City of Portland, Maine - Building or Use Permit Application
 389 Congress Street, 04101 Tel: (207) 874-8703, Fax: (207) 874-8716

| Permit No: 05-1415 | Issue Date: | CBL: 014 B005001 |

| Location of Construction: 16 Cumberland Ave | Owner Name: Carlson Dale A & Judith A Jts | Owner Address: 61 Westwood Rd | Phone: 428-4272 |

| Proposed Project Description: Interior renovations to apartment #1. | | FIRE DEPT: <input type="checkbox"/> Approved <input type="checkbox"/> Denied | INSPECTION: Use Group: Type | |

16-18 CUMBETLAND

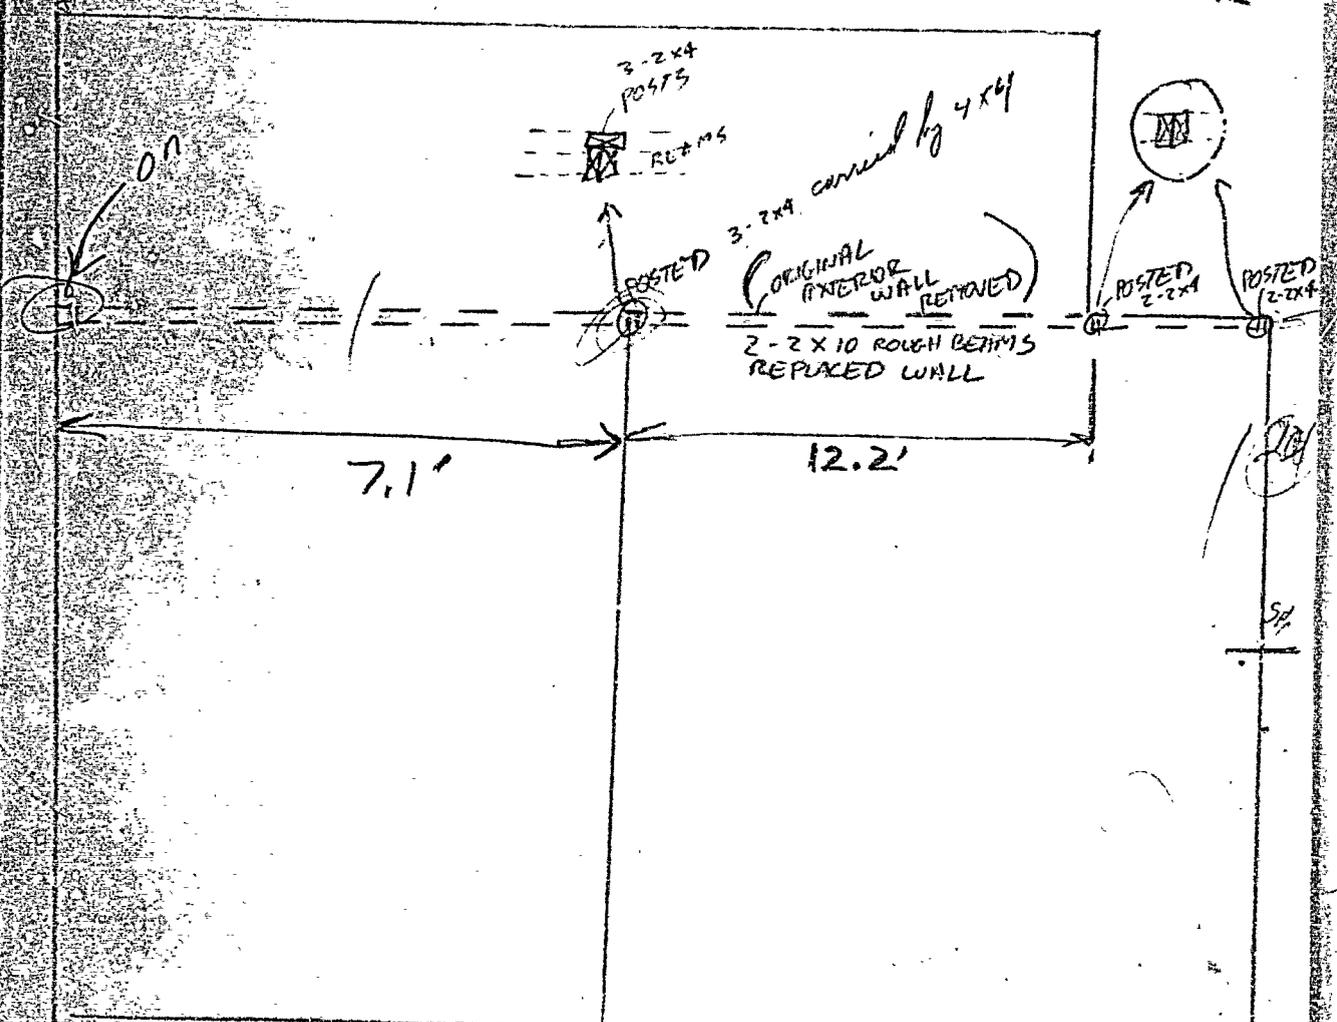
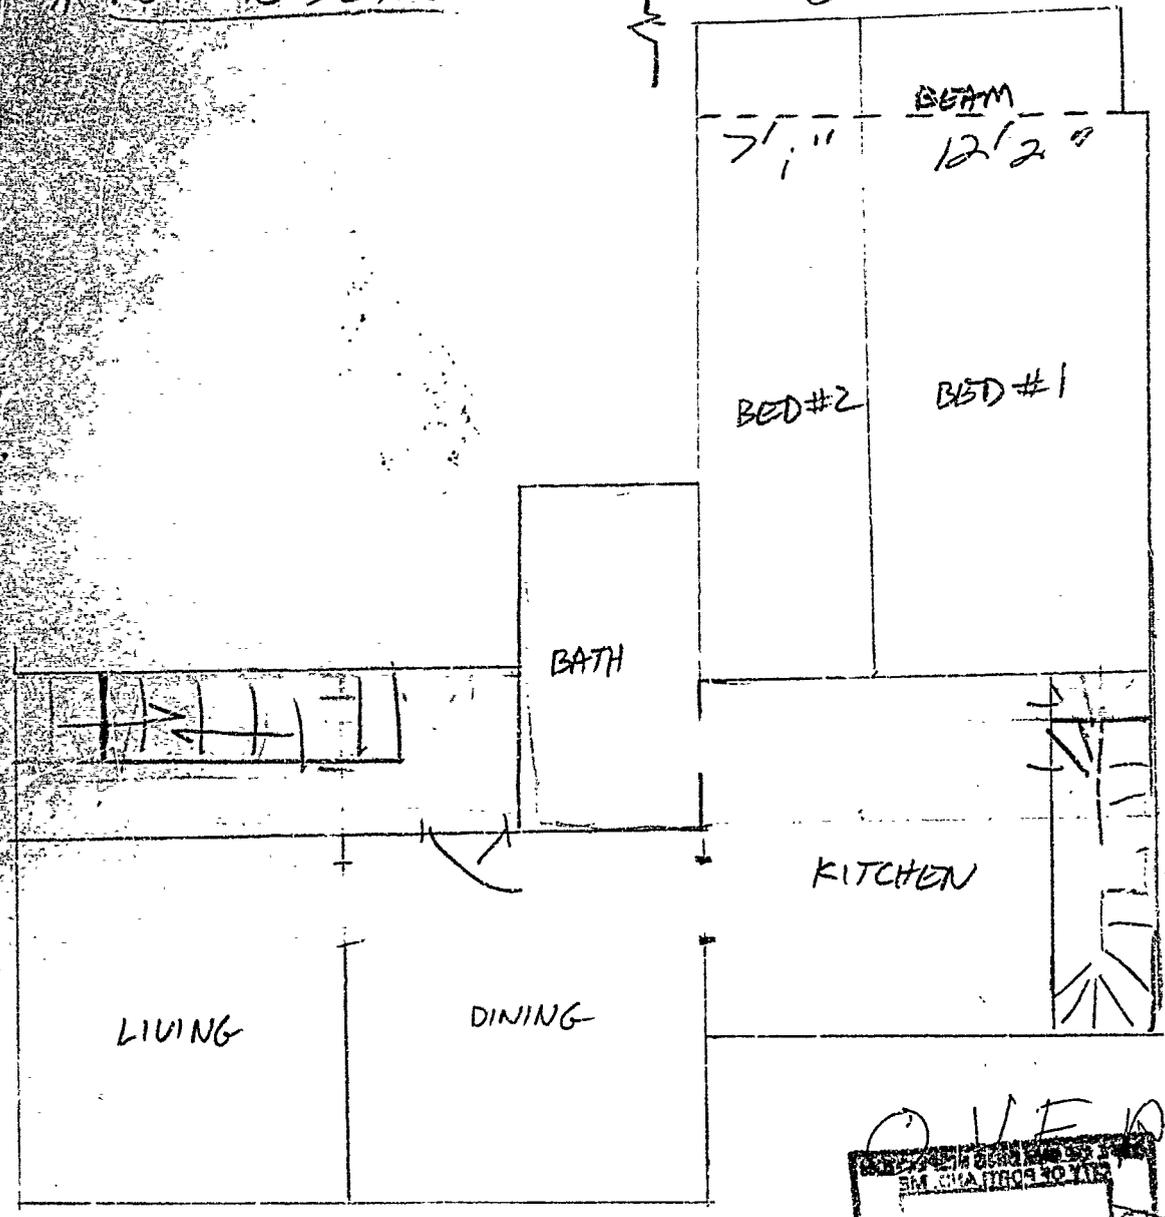
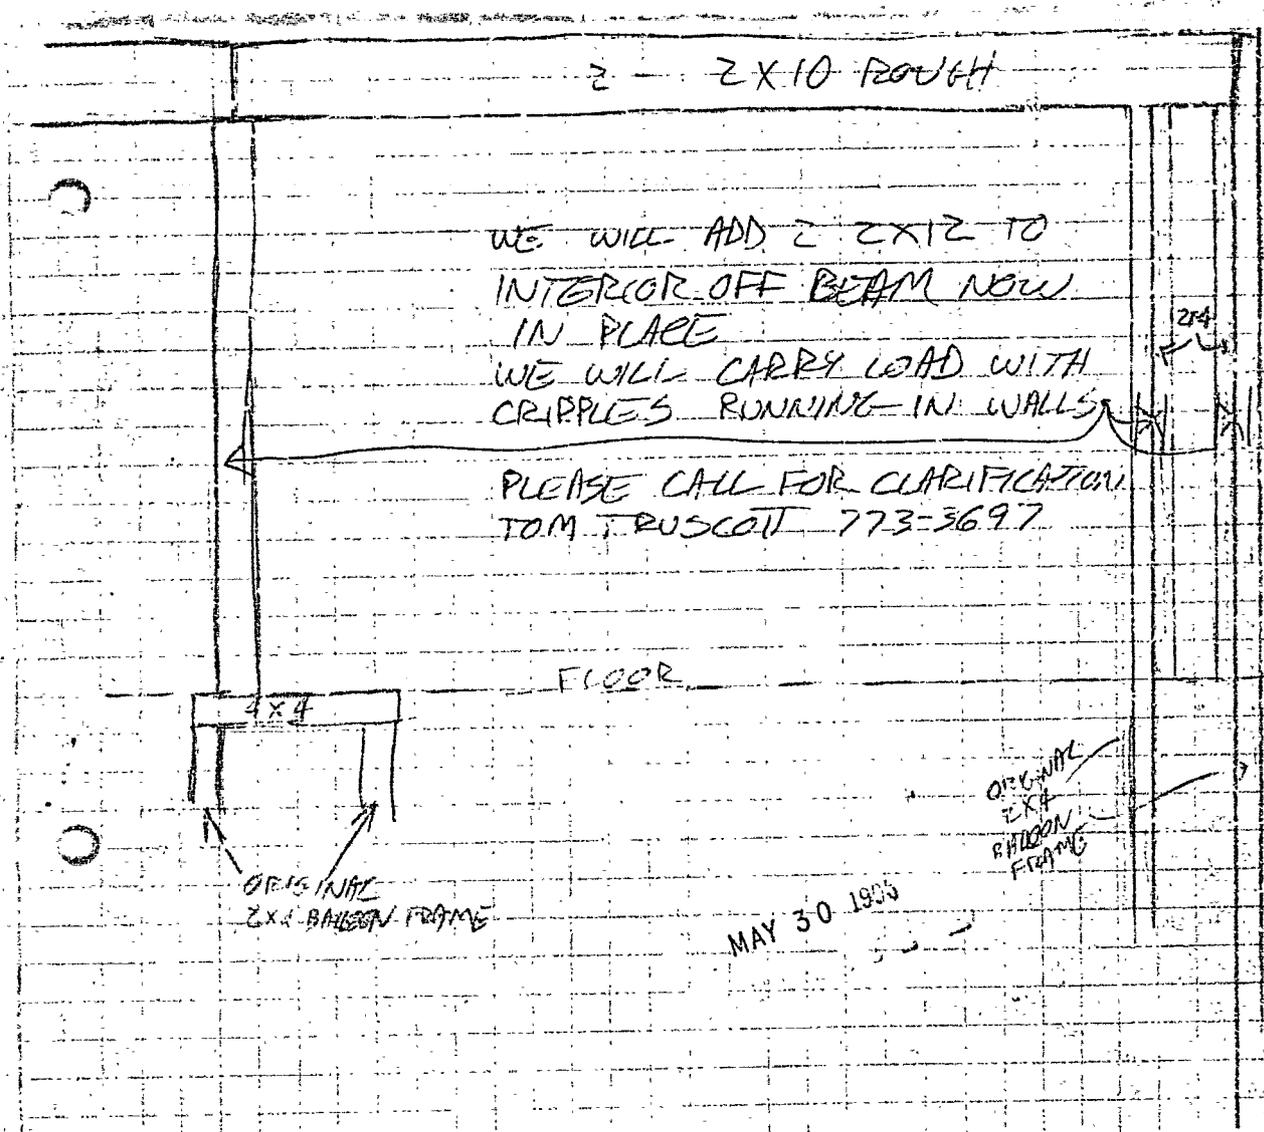
- 1) The final beam and bearing alteration as shown on the plans must be resubmitted and approved prior to construction.
- 2) All renovated ceilings and wallse separating units from stairways. must have a one hour fire resistance rating with an STC of 50. Newly installed doors from units into common halls or stairs must be 45 Minute doiors and Frames. Please be advised that the Fire Code is potentially more restrictive and will require one hour doors. If this is the case the one hour door must be installed.

10/13/2005-mjn: Left message with the owner re: point loads generated from the opening of the wall and also fire separation of units.
10/24/2005-ldobson: brought in some additional info. LJD
